CITY OF ALBUQUERQUE

March 24, 2015

RE: **Whataburger
Grading and Drainage Plan
Engineer's Stamp Date 2-18-2015 (File: K10-D001B)**

RE: **Whataburger
Grading Plan
Engineer's Stamp Date 2-18-2015 (File: K10-D001B)**

GRADING AND
DRAINAGE PLAN

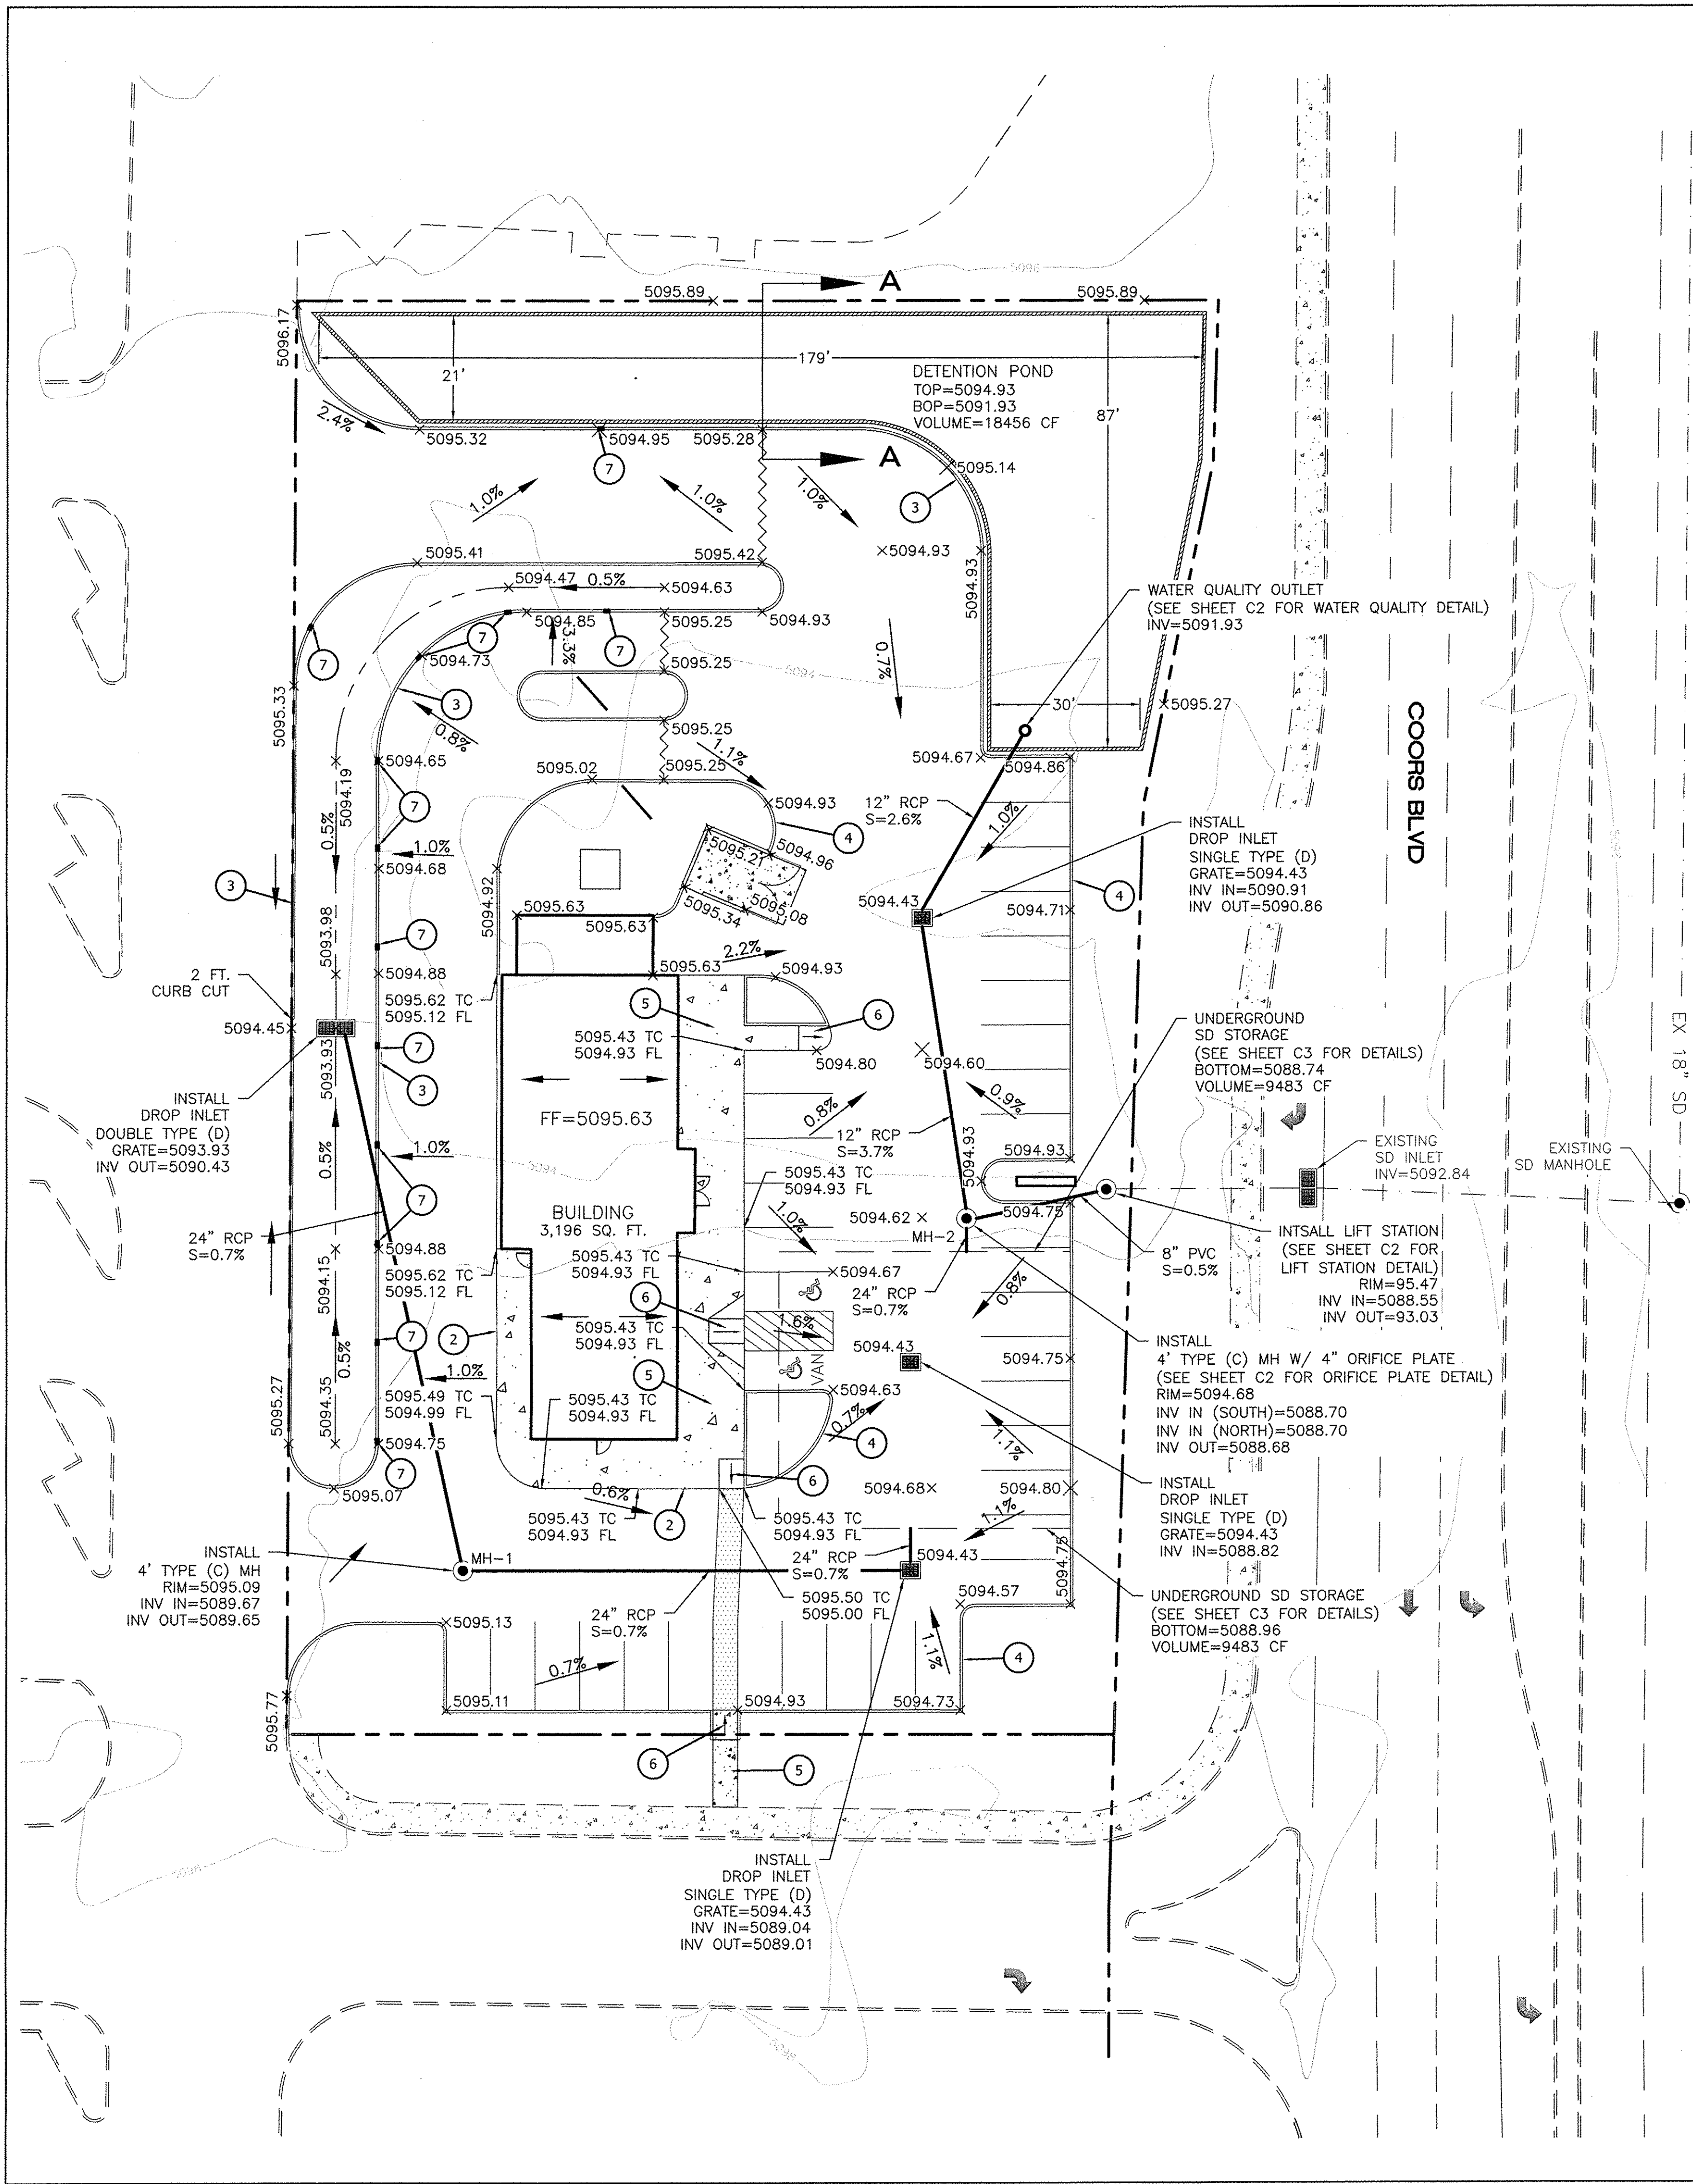
- 2) On the plan view for the "Grading and Drainage Plan", label all of the different detention volumes that correspond to the "Proposed Conditions" discussion which include the 0.43 ac-ft detention pond, the 0.16 ac-ft surface pond, and the underground storage of 0.22 ac-ft. Show the underground storage system area on the plan view for the "Grading and Drainage Plan", and label the connections from the new 24-inch storm drain to this underground storage system.

- 3) There is a Section A-A on the "Grading and Drainage Plan" which shows pond elevations within the detention pond in the north area of the site. Provide more spot elevations within this area at the corners of the pond to ensure that there will be enough volume provided for the detention pond.

- 5) How is storm drainage getting to the Double-D inlet on the west side of the site? Provide capacity calculations for the 5.6-foot wide curb cut that is accepting the off-site flow from the west and adjust as necessary.

- 6) Provide capacity calculations for all of the curb cuts shown on the plan.

- 8) It is not clear if the subject site is accepting off-site flows from the site or how the site to the north will be impacted. Include discussion of off-site flows from the site to the north to ensure that grading of the Whataburger site does not adversely impact this site.

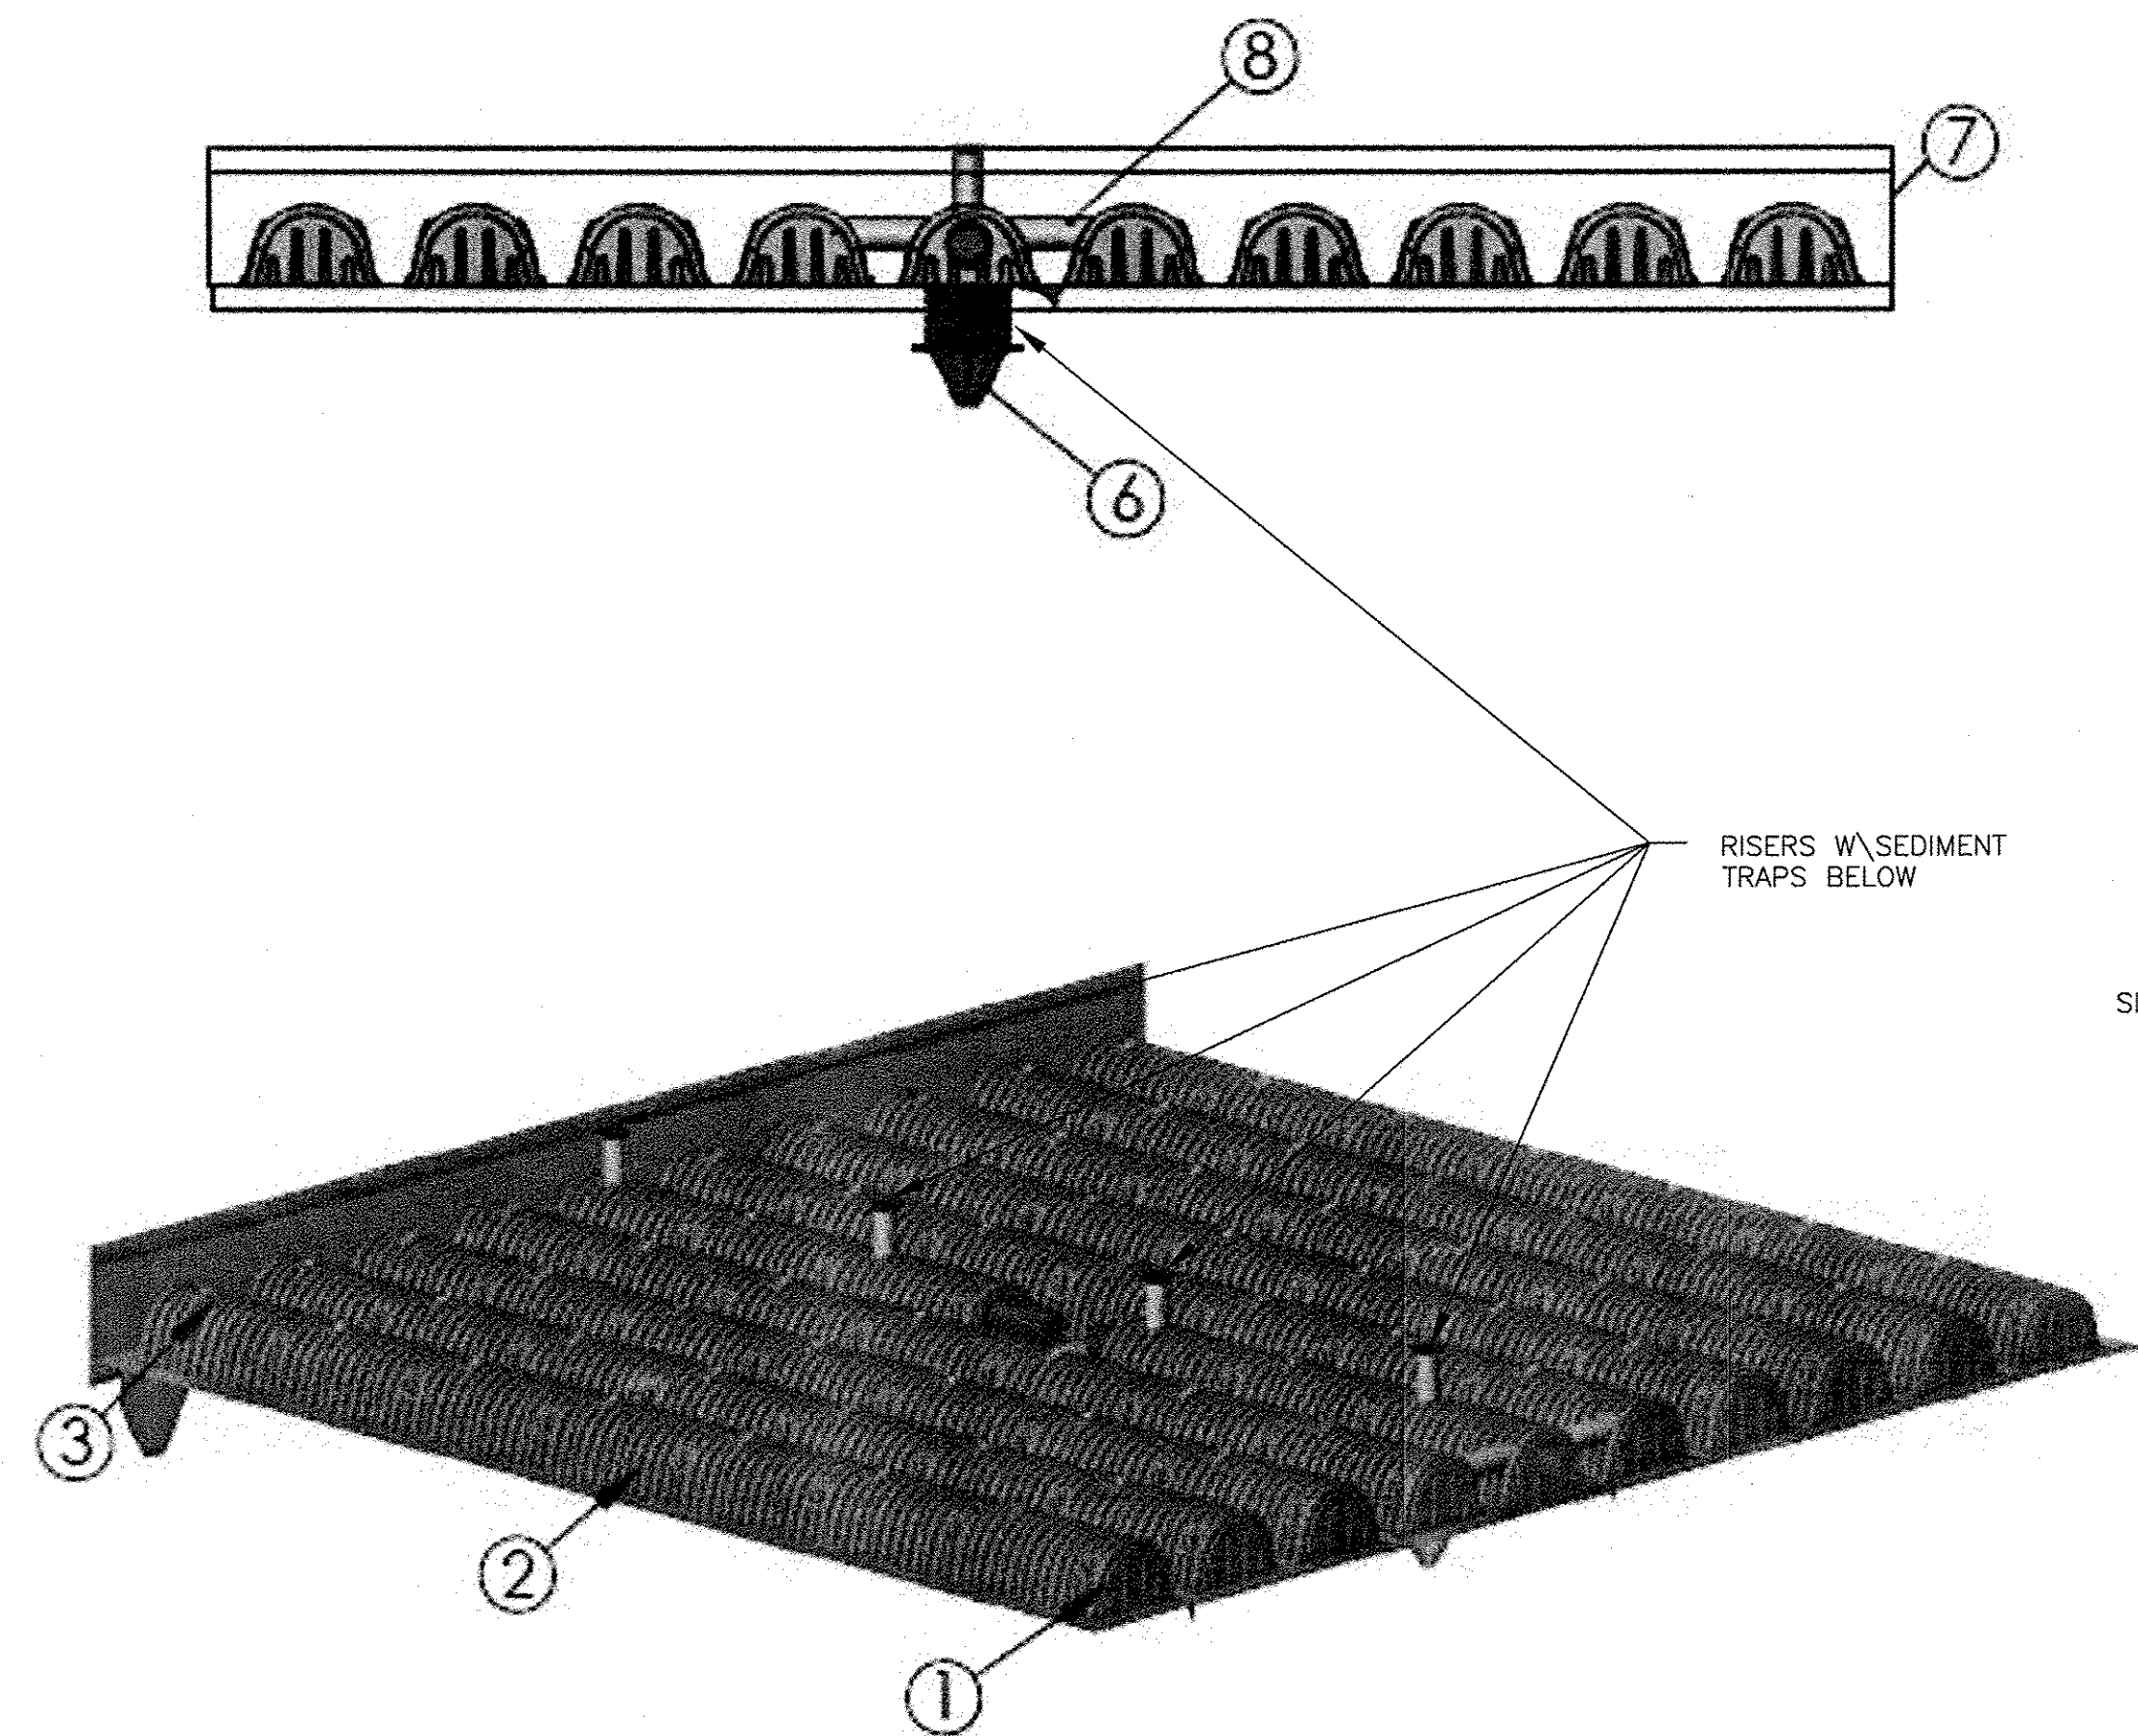
- 7) A summary table is provided for grate capacities and pipe capacities on the "Basin Map and Calculations" sheet. Please provide the calculations for these capacities.
